**KIRKLEES METROPOLITAN COUNCIL
INVESTMENT & REGENERATION SERVICE**

DELEGATED DECISION TO DETERMINE PLANNING APPLICATIONS

Reference No:	2021/62/93391/W
Site Address:	Mytholmbridge Farm, 36, Luke Lane, Thongsbridge, Holmfirth, HD9 7TB
Description:	Partial demolition of dwelling, erection of two-storey side and rear extensions, porch, link extension, detached garage and external alterations
Recommending Officer:	Sam Jackman

DECISION - REFUSED

rear elevation - north east

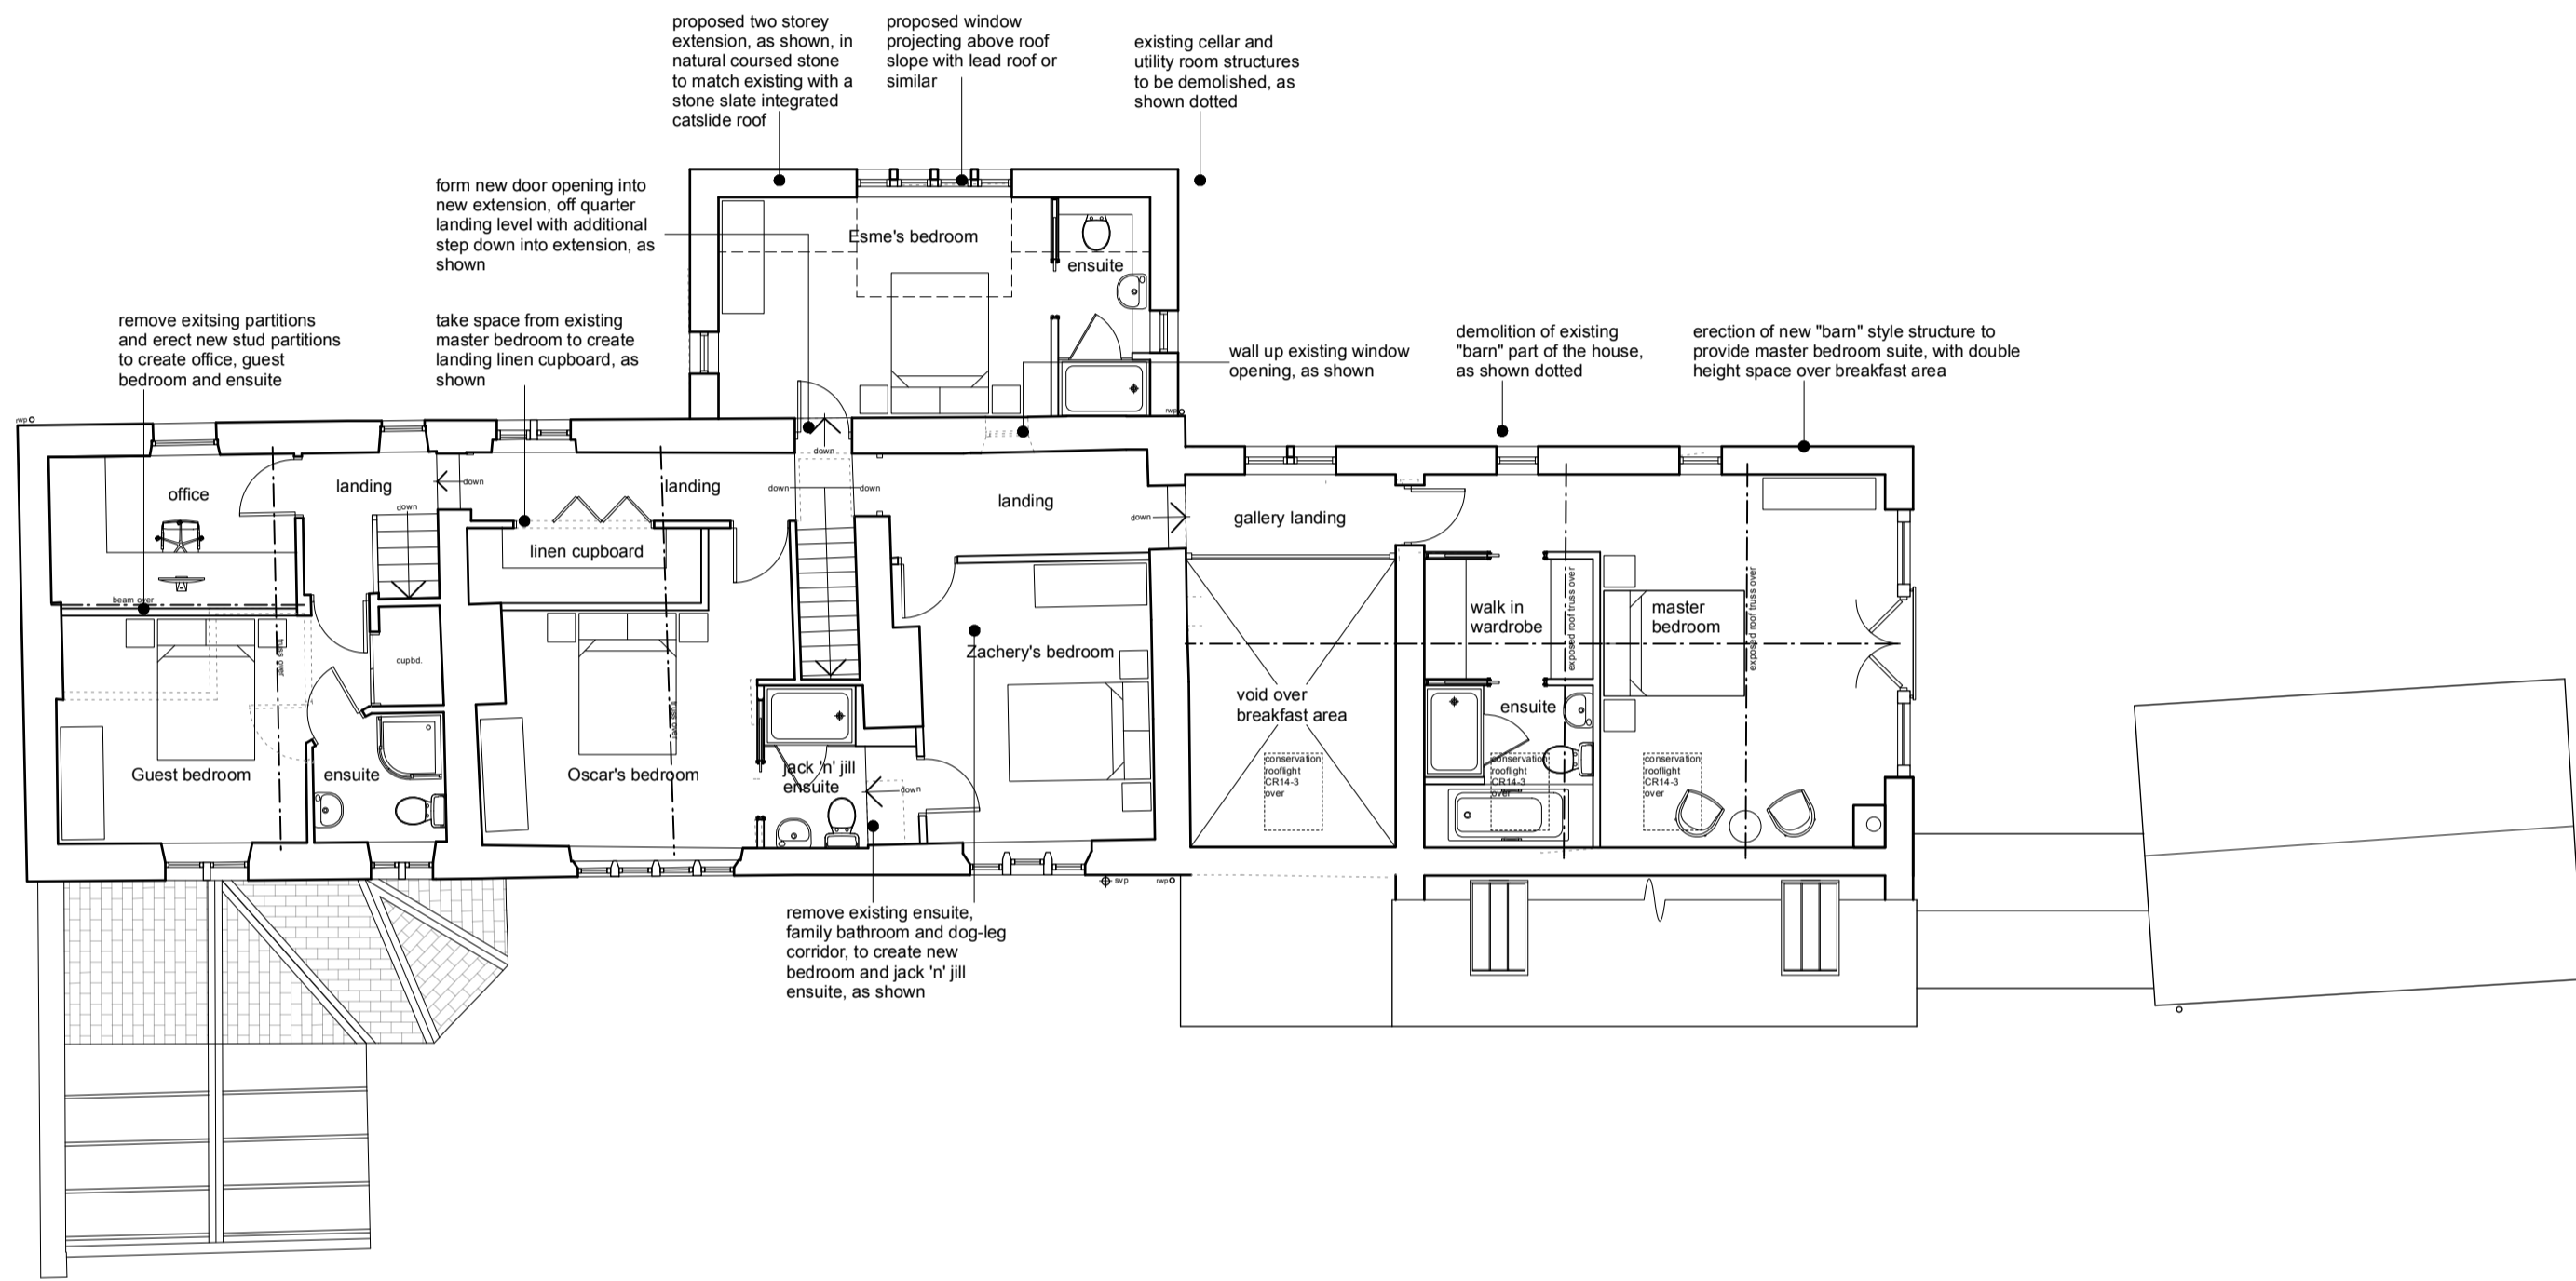
The plans originally included a gable to the rear 2- storey extension which has been amended to a long lean-to roof, joined into the host properties roof with a projecting first-floor window as demonstrated within the supporting statement.

This is especially evident on the rear elevation where the new building wholly eradicates the original character of the farmhouse, this is contrary to LP57 criteria a. Albeit policy LP57 along with the NPPF doesn't refer to acceptable percentage increases, as each application is taken on its own merit as it depends on how any increase would be proportionate or not. In this case all the extensions, including the existing ones and proposed would amount to an approximate additional volume of 80%, where the majority of this relates to the 2-storey rear and side extension located in close proximity with one another on the east corner of the building. The appearance of the property when approaching from the entrance and view from across the field to the east would be altered such that the openness of the Green Belt would be impacted upon.

With regards to the fenestration details of the rear elevation, the two-storey rear extension has been amended by removing the gable and introduce a lean-to roof or catslide roof. Where the agent states catslide roofs are characteristic within the area, this is not disputed and in principle is considered to be acceptable. However, the proposed roof doesn't follow the characteristics of a catslide roof in that it is not a continuation of the main roof which should drop down so that the new eaves are low to the ground. In this case the eaves are just below the main roof and the extension introduces a flat roofed style dormer with mullion cottage windows as shown in the agents supporting statement. However, it's not clear which property this relates to or if its to a rural farm cottage, regardless of this the design is considered to be unacceptable and inappropriate on the rear elevation of this rural farmhouse cottage.

Furthermore the original farmhouse follows the historically characteristic of properties within the area where they have no access at the rear as the property butts up against the adjacent field. The rear extension would substantially change the appearance of this farmhouse cottage in its rural setting by providing a rear access by lowering the ground level and extending the domestic curtilage into the adjacent field. Albeit this area is small this feature is considered erode into the rural character and would be harmful to visual amenity and the significance of this building, furthermore its not clear how the existing field will be retained or if any new boundary treatment will be built. Both these elements could clearly add to the urban appearance to this property which would be also unacceptable.

side elevation - south east

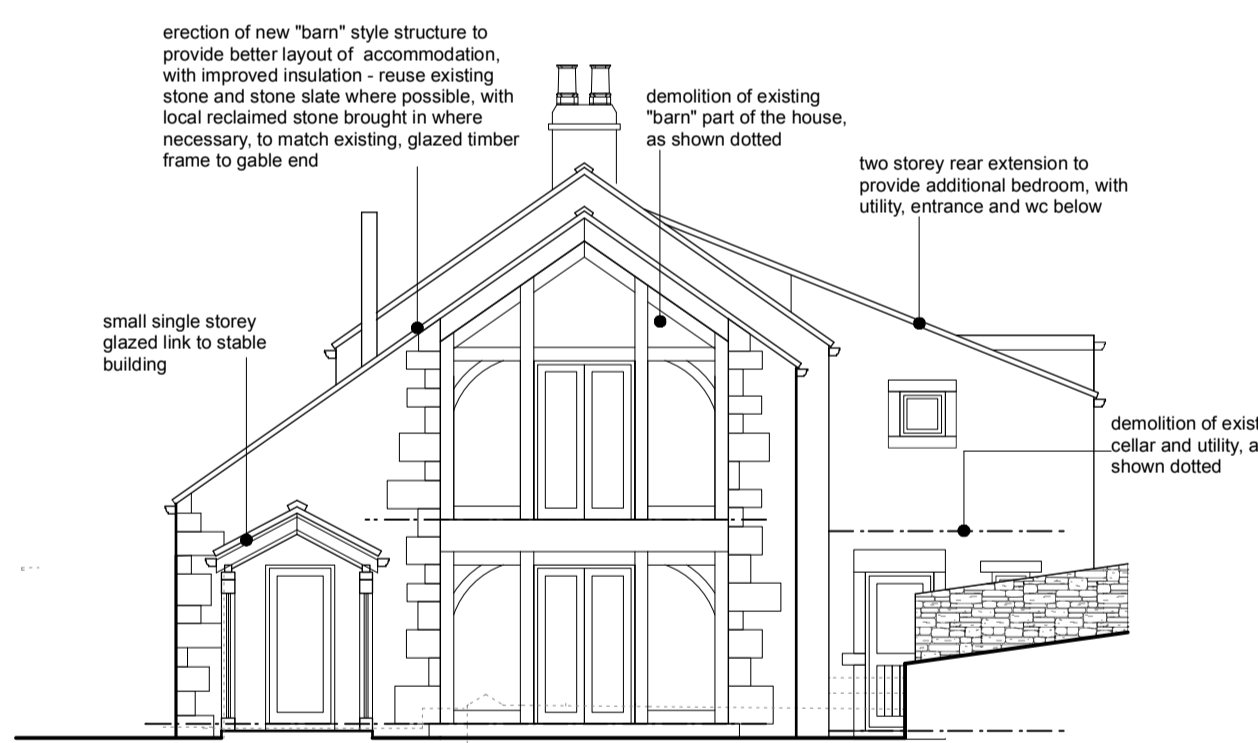
The new side extension replacing the converted barn, would be square in footprint removing its miss shaped character, it is accepted the ridge is lower than the host property but only by 0.5m with the front elevation repeating the catslide roof which is acceptable. However, the window details within the extension introduce 3 additional first-floor rear windows, regular in form which wouldn't have been acceptable if added as part of the original barn conversion, along with 5 rooflights within the new roof, however, it is accepted that there are already 3 existing rooflights. Therefore, adding domestic features to an extension where the agent states the proposal was carefully designed to retain the features and character of the existing structure.

However, it is the gabled elevation of the barn that gives the most concern by introducing a large expanse of glazing within a visible oak frame which would be approx. 3.8m wide extended into the apex of the roof. The glazing would have inward opening doors to both floors, introducing a Juliette balcony with windows either side and would be edged with large quoins, traditional used on the corner of buildings.

Barns of this period and in this area would usually have blank gables with any large openings located on the front elevation. The use of timber frame in the form of a crook barn are found within the area, however, wouldn't be visible from the outside. Therefore, these fenestration details are considered to detract from the overall character and appearance of the host property. Whilst

it is noted that the existing barn has some glazing in the side elevation however, this feature is not original to the barn, however, is small in scale and appeared to replicate a smaller window to the mezzanine floor. The proposed new window would be considered to be unacceptable due to its large expanse of glazing which would add an incongruous feature and wouldn't reflect the structure its replacing.

2. The proposed extensions by reason of their combined scale and design incorporating a large expanse of glazing to the side elevation of the proposed side extension would not represent a subservient addition to the host building or be in keeping with the property in terms of its scale and detailing. The proposed extensions would form an unsympathetic, incongruous and overly prominent form of development which would harm the character and appearance of the host property and surrounding area and would therefore fail to accord with Policy LP24 (a) and (c) of the Kirklees Local Plan, Principles 1 and 2 of the House Extensions and Alterations SPD, policy 2 of the Holme Valley Neighbourhood Plan and Policies in Chapter 12 of the National Planning Policy Framework.

plan - garage

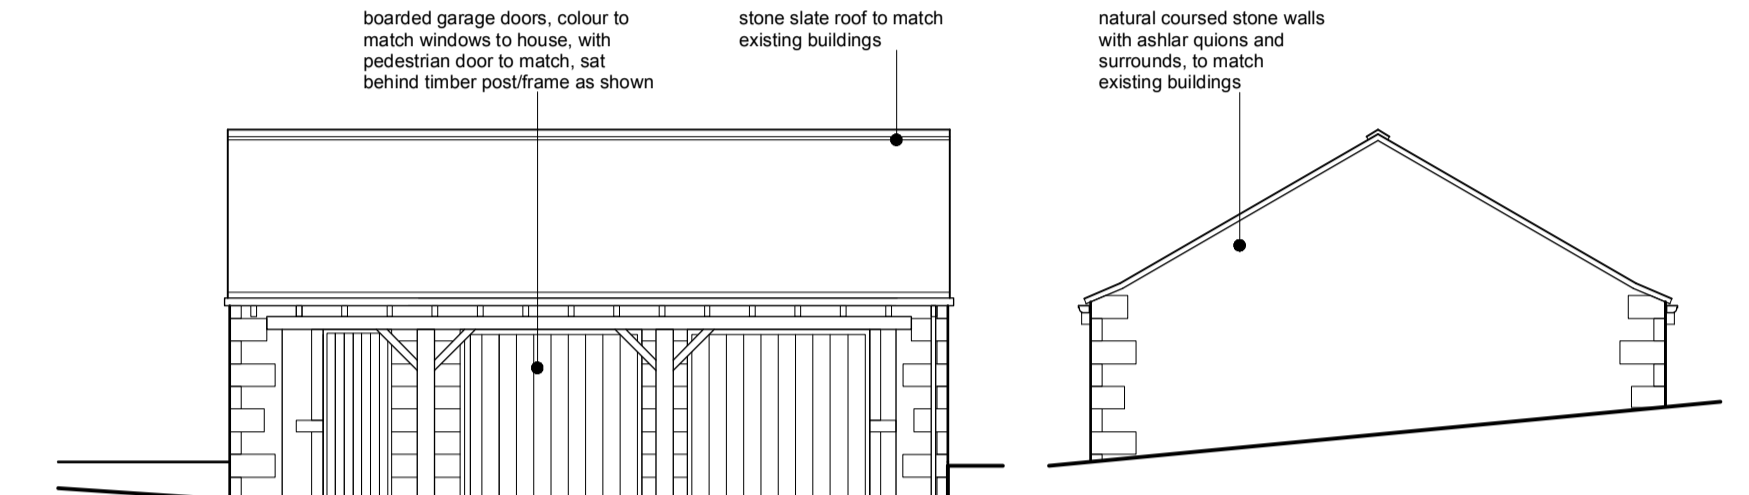
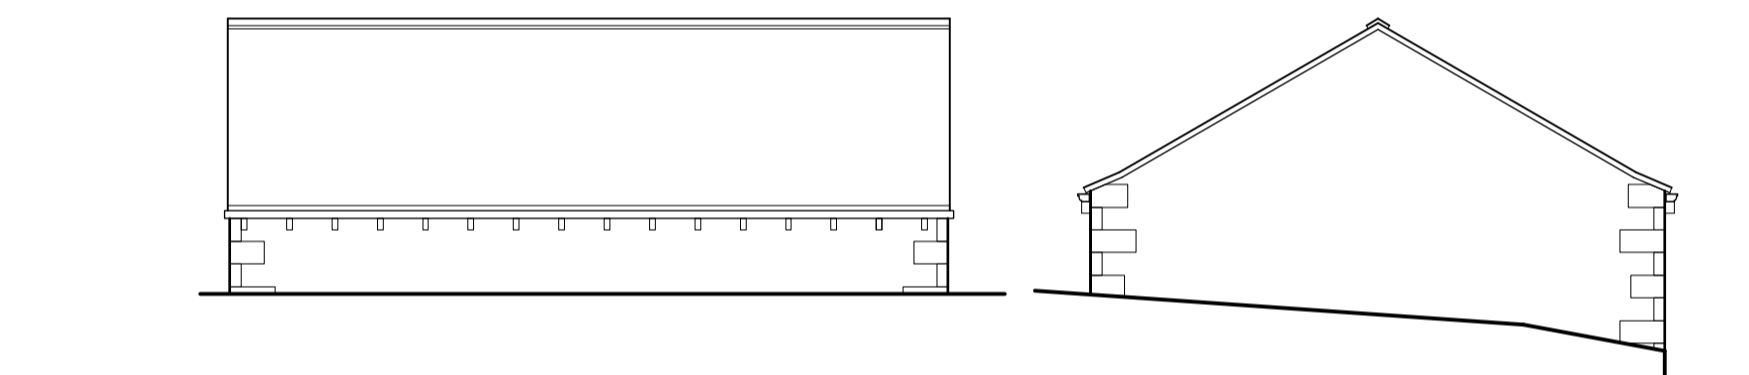
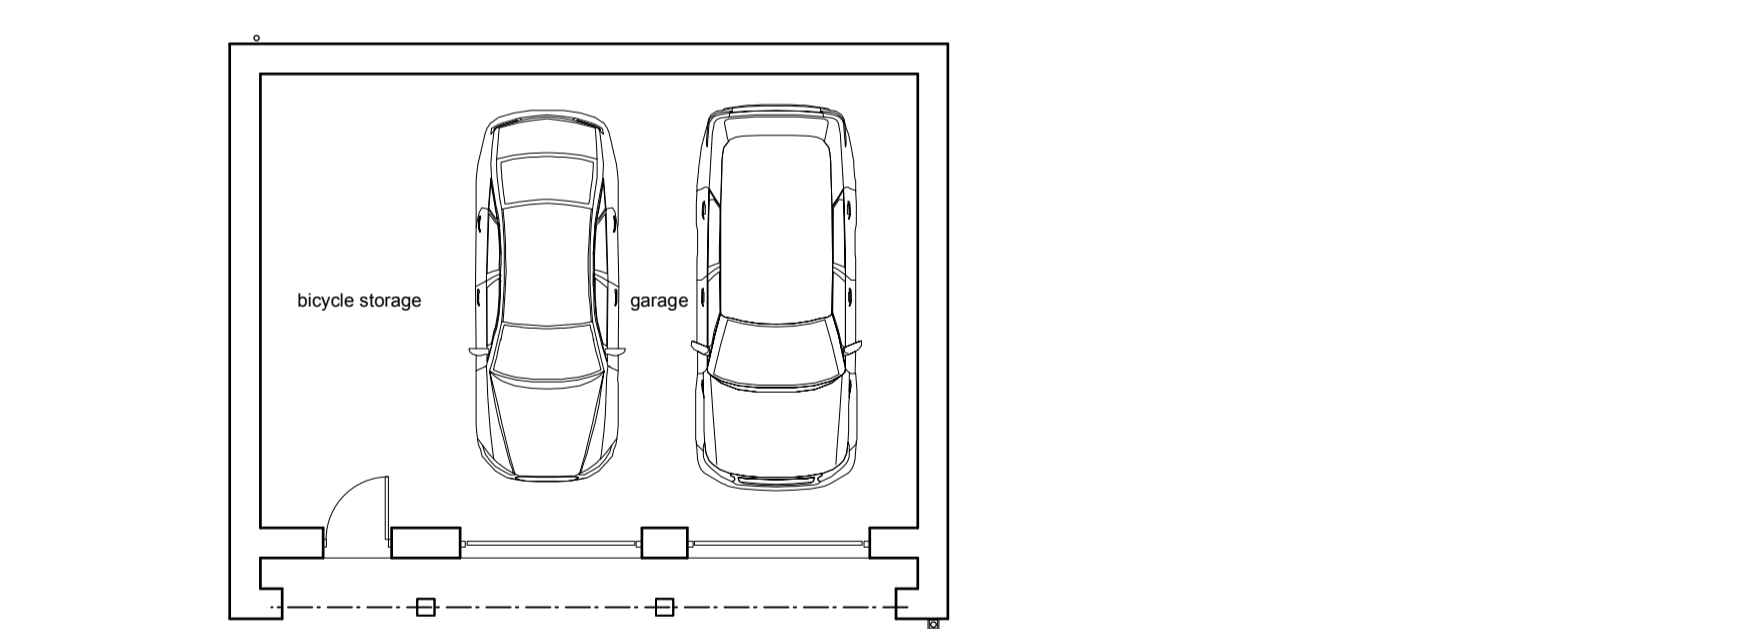
The detached garage is fairly large and the small, covered entrance is considered to be acceptable in its design it adds additional unnecessary mass to the building. however, this could be easily amended if the scheme was considered as whole to be acceptable.
